May 31, 2024

**Re: Taco Bell 1125 Snow Vista SW**  
**Traffic Circulation Layout**  
Engineer's/Architect's Stamp 5-24-2024 (M09D012D)

Based upon the information provided in your submittal received 5-29-2024, the above referenced plan cannot be approved for Building Permit until the following comments are addressed:

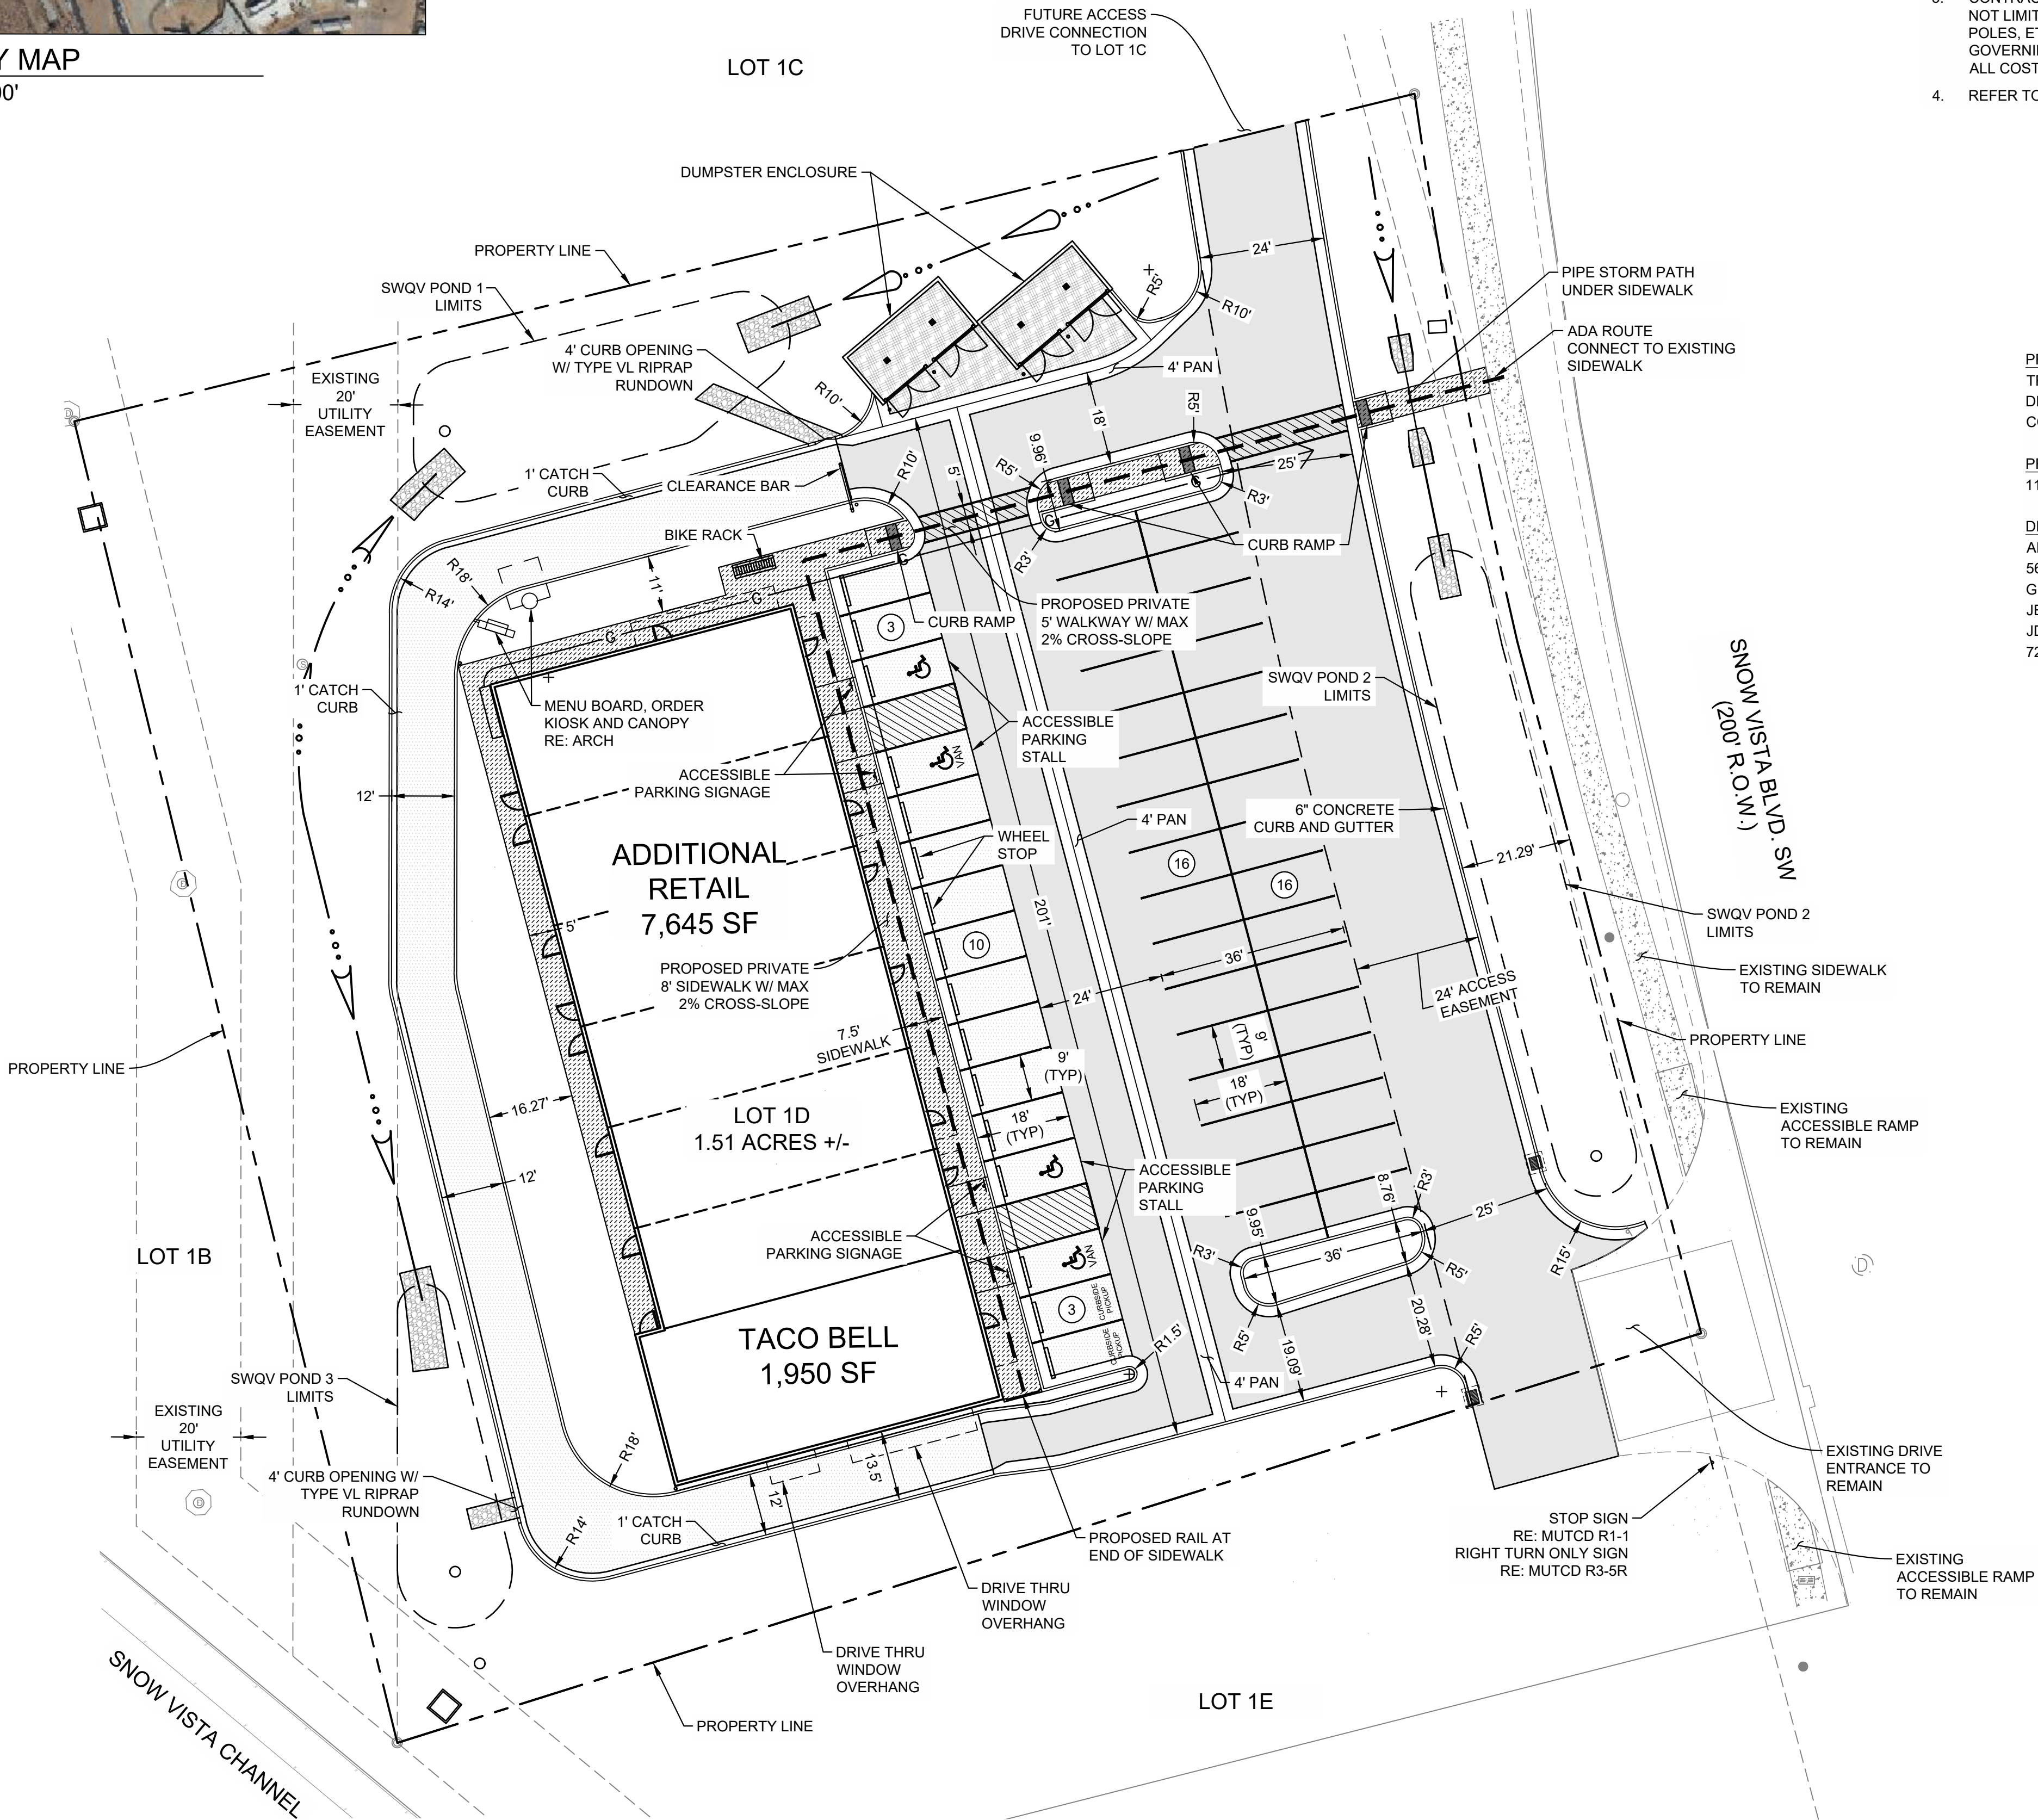
1. Add to your list the number of parking spaces required by the IDO for bicycles and motorcycle parking.

2. Identify the medians, curb cuts, and street widths on Snow Vista Blvd.
3. Show all accesses to the site with dimentions.Maximum access width for arterial, collector, and local streets are as follows:

4. All accessways to the site from the adjacent roadway shall be ADA-compliant.

5. Proposed accessways must be set back from the property line such that the top landing for the ramp built as part of these accessway does encroach in the area immediately in front of the adjacent property. The end of the curb radius for these accessway shall also not extend to this area.
6. Please list the width and length for all proposed parking spaces. Some dimensions are not shown.
7. The minimum parking stall dimensions are:

8. Label the compact parking spaces by placing the words "**COMPACT**" on the pavement of each space.
9. Parking spaces cannot be bisected by lot lines.

10. The ADA accessible spaces must include an access aisle. Van accessible aisles should be 8ft wide; all others should be 5ft wide.
11. The ADA accessible parking sign must have the required language per 66-7-352.4C NMSA 1978 "**Violators Are Subject to a Fine and/or Towing.**" Please call out detail and location of signs.

12. The ADA access aisles shall have the words "**NO PARKING**" in capital letters, each of which shall be at least one foot high and at least two inches wide, placed at the rear of the parking space so as to be close to where an adjacent vehicle's rear tire would be placed. (66-1-4.1.B NMSA 1978)

13. ADA curb ramps must be updated to current standards and have truncated domes installed.
14. Motorcycle parking spaces shall be designated by its own conspicuously posted upright sign, either free-standing or wall mounted per the zoning code.

- f. Each bicycle parking space is accessible without moving another bicycle.
16. Bicycle racks shall be sturdy and anchored to a concrete pad.
  17. A 1-foot clear zone around the bicycle parking stall shall be provided.
  18. Bicycle parking spaces shall be at least 6 feet long and 2 feet wide.
  19. Show all drive aisle widths and radii. Some dimensions are not shown.
  20. Show the drive through queuing diagram (A line of vehicles waiting as in a drive through facility). A minimum of 12 stacking spaces are required.
  21. The minimum drive aisle dimensions are shown below

22. List radii for all curves shown; for passenger vehicles. Radius for delivery trucks, fire trucks, etc. is 25 ft. or larger.
23. Per the DPM, a 6 ft. wide ADA accessible pedestrian pathway is required from the public sidewalk to the building entrances. Please clearly show this pathway and provide details.

24. Per DPM, a 6 ft. wide ADA accessible pedestrian pathway is required from the ADA parking stall access aisles to the building entrances. Please clearly show this pathway and provide details.

25. ADA accessible pedestrian pathway should not be placed behind parking space or adjacent to a vehicular way. Vehicle and pedestrian/wheel chair conflicts should be avoided as much as possible.

26. Curbing should be installed to delineate landscape, parking, and pedestrian ways and identify points of access. Please call out detail and location of barrier curb.

27. provide a copy of Solid Waste Dept approval for dumpsters locations and also the Fire Dept.approval.
28. All one-way drives shall have "One Way" and "Do Not Enter" signage and pavement markings. Please show detail and location of posted signs and striping.

29. The minimum drive through lane width is 12 feet with a 25 foot minimum radius (inside edge) for all turns. (A 15 foot radius can be used with an increase in lane width to 14 feet). Please dimension all lane widths and radii.

30. Show the clear sight triangle and add the following note to the plan: "Landscaping and signage will not interfere with clear sight requirements. Therefore, signs, walls, trees, and shrubbery between 3 and 8 feet tall (as measured from the gutter pan) will not be acceptable in the clear sight triangle.

31. Shared Site Access: driveways that straddle property lines, or are entirely on one property but are to be used by another property, shall have an access easement. Please include a copy of your shared access agreement with the adjacent property owner.

32. Work within the public right of way requires a work order with DRC approved plans.
33. Please add a note on the plan stating "All improvements located in the Right of Way must be included on the work order."

34. Unused curb cuts must be replaced with sidewalk and curb & gutter. A build note must be provided referring to the appropriate City Standard drawing.

35. Add a note stating "All broken or cracked sidewalk must be replaced with sidewalk and curb & gutter." A build note must be provided referring to the appropriate City Standard drawing.

36. Show all private infrastructure outside of public right-of-way and all public infrastructure within public right-of-way. Any private infrastructure that is allowed by the City of Albuquerque to be kept within right-of-way shall require a revocable permit.

37. Show location of overhead utility lines in relationship to the buildings.
38. Traffic Studies: See the Traffic Impact Study (TIS) thresholds. In general, a minimum combination of 100 vehicles entering and exiting in the peak hour warrants a Traffic Impact Study. Visit with Traffic Engineer for determination, and fill out a Traffic Scoping Form (TSP) Form (see the attached) that states whether one is warranted. In some cases, a trip generation may be requested for determination (**Contact Curtis Cherne: [CCherne@cabq.gov](mailto:CCherne@cabq.gov)** ).
